**WEST SUSSEX COUNTY COUNCIL
PLANNING SERVICES CONSULTATION**

SUBJECT: WA/68/17/PL - Vehicular farm field entrance.

Land adjacent to The Meads, Barnham Lane, Barnham

Drawing	
Planning Application	
Site Plan	
Proposed Farm Field Entrance

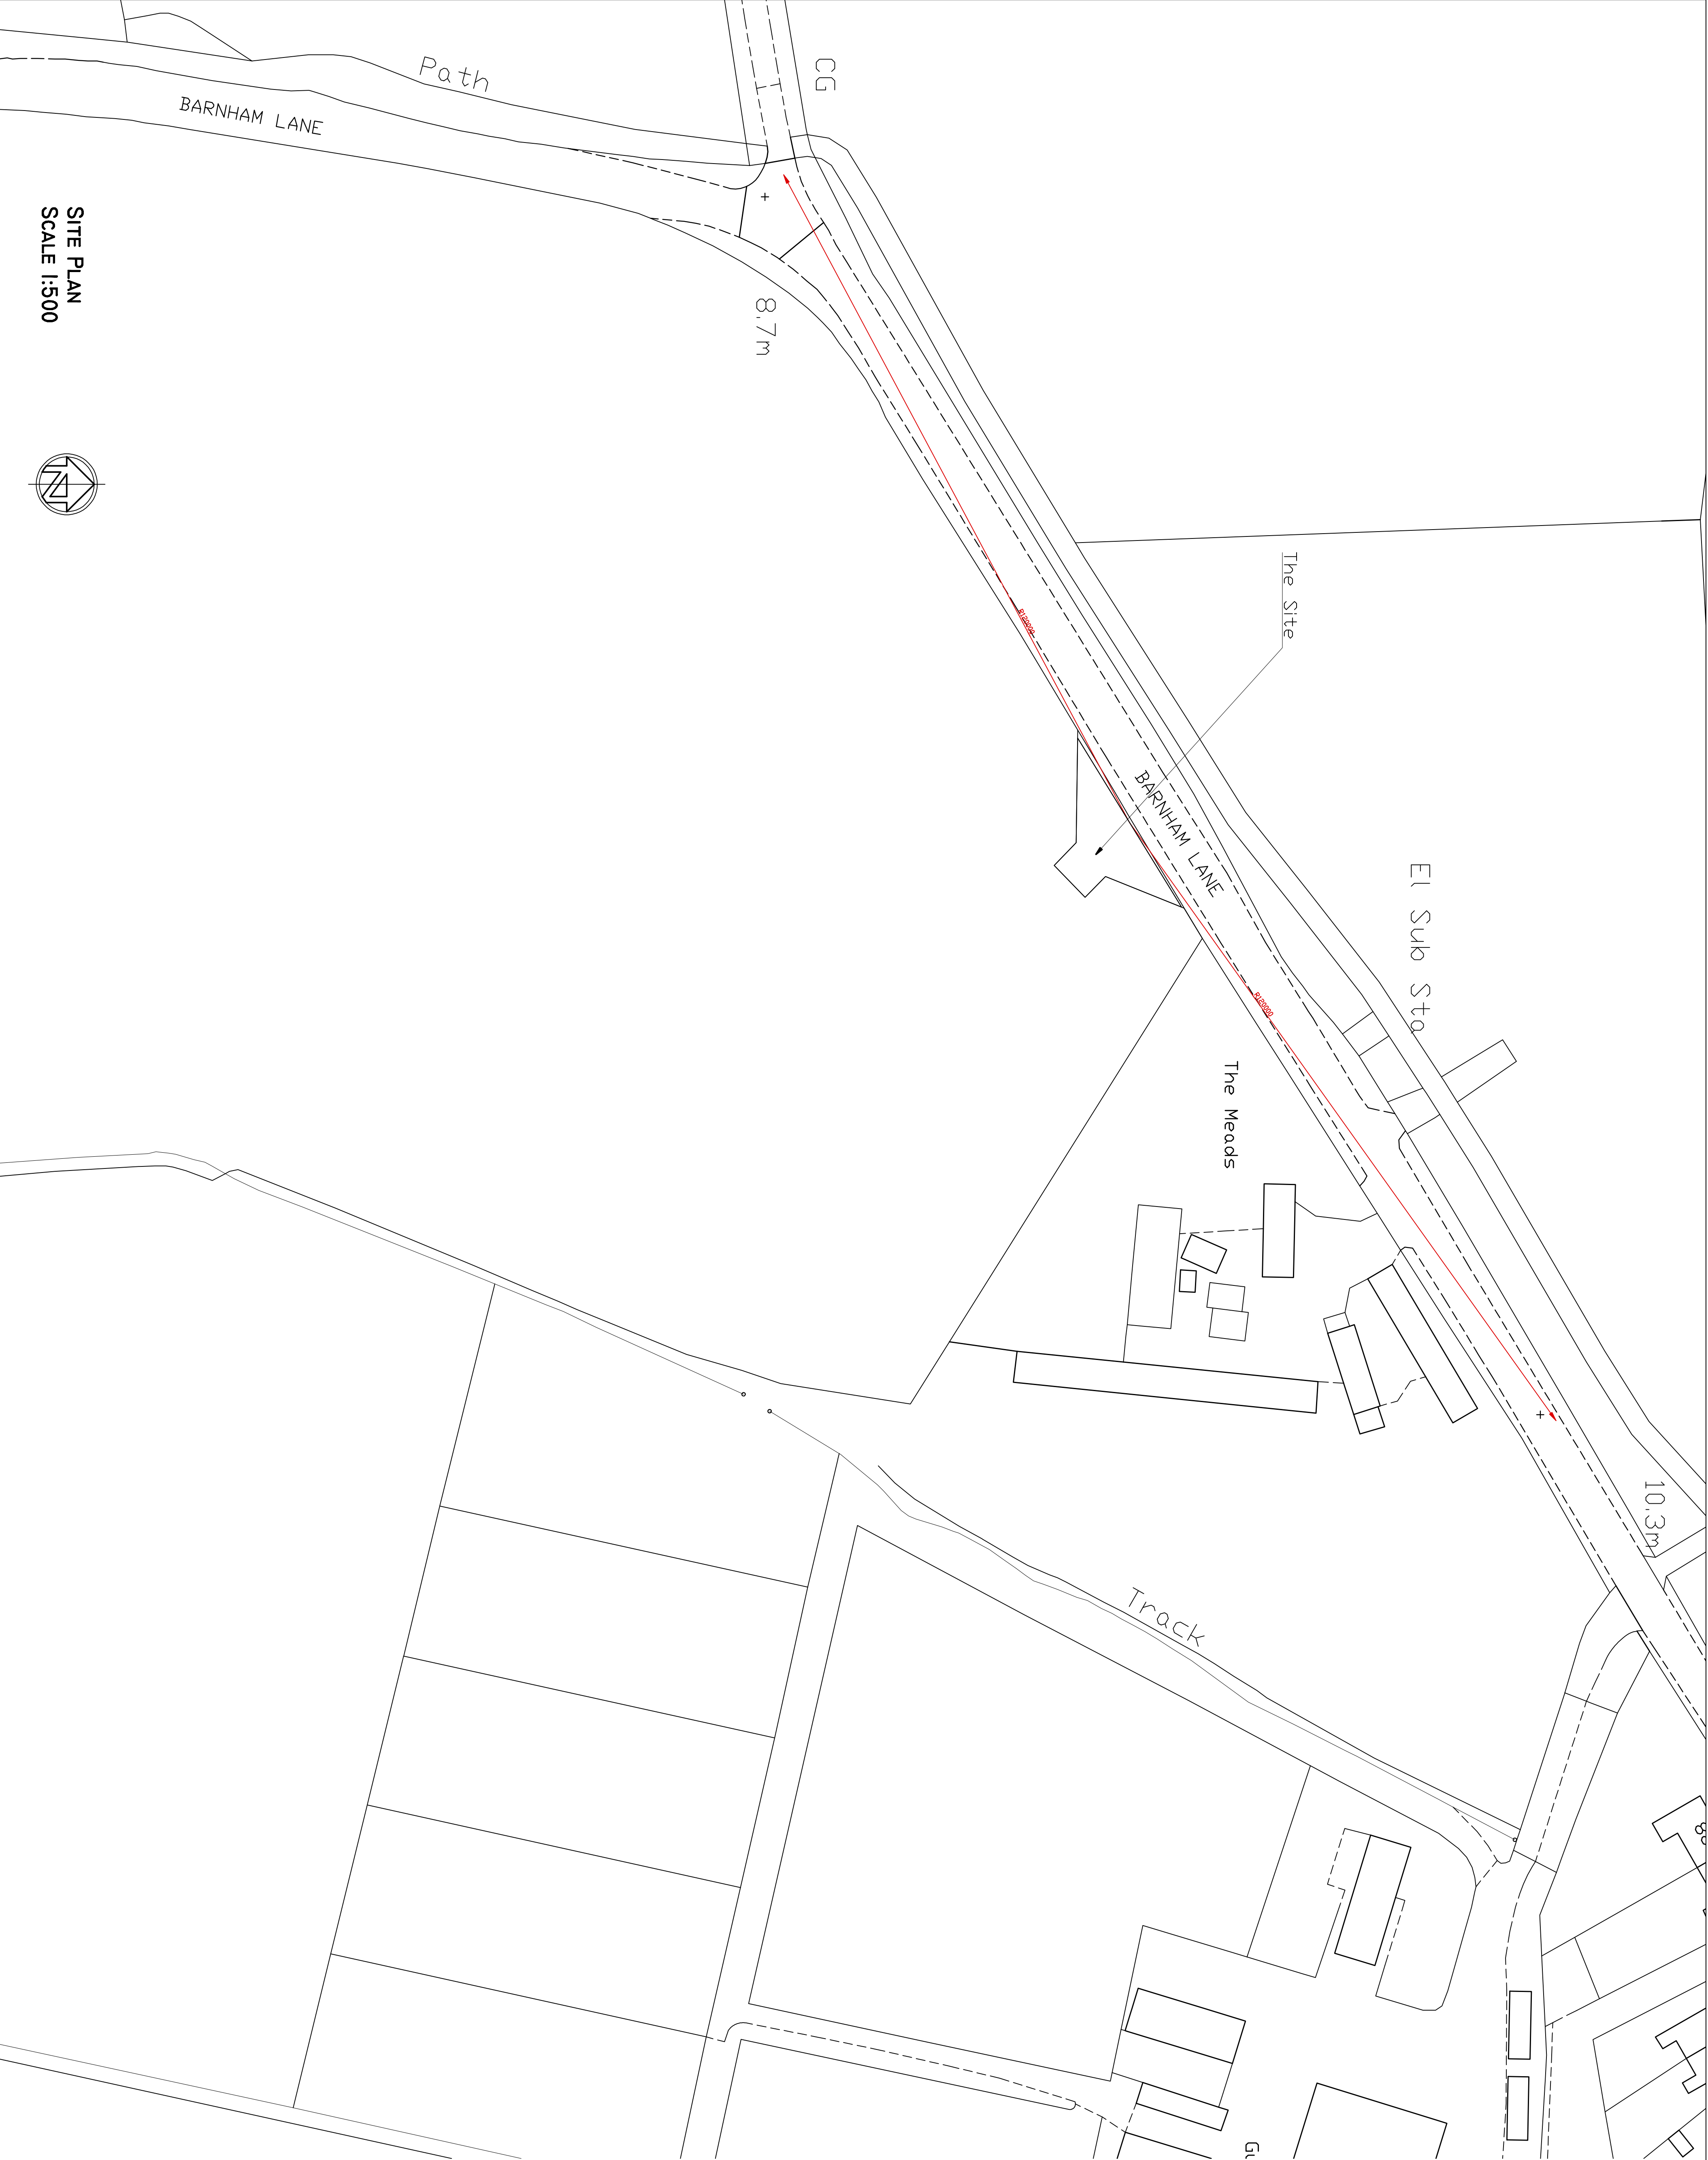
The applicant has demonstrated visibility splays of 2.4 x 120 metres in each direction. This length of splay would be considered adequate for the design speed of Barnham Lane in accordance with the Design Manual for Roads and Bridges (TD/9/93). However the splays have been drawn to a point on the far side of the carriageway in each direction. The splays should be drawn to a point on the nearside carriageway edge, though it would be appropriate to draw the splays with a 1.0 metre offset to represent the edge of a vehicles track. I would ask the applicant demonstrate maximum achievable visibility splays as described above. This will likely have an impact on the hedging immediately adjacent to the proposed access point.

The access point proposed is 6 metres in width and secured with an inwardly opening gate set back 16 metres from the Barnham Lane carriageway. The proposed access is to be set out with kerb radii. Given this type of access requires excavation of the Highways it will need to be implemented via a Section 278 Agreement. The Local Highways Authority would advise that a vehicle crossover would be a more appropriate and sympathetic means of access. This can be implemented under licence to a heavy duty specification obtained from WSCC Highways.

In conclusion I would request that the applicant provide modified visibility splays as described above and the Local Highways Authority be re consulted on this application.
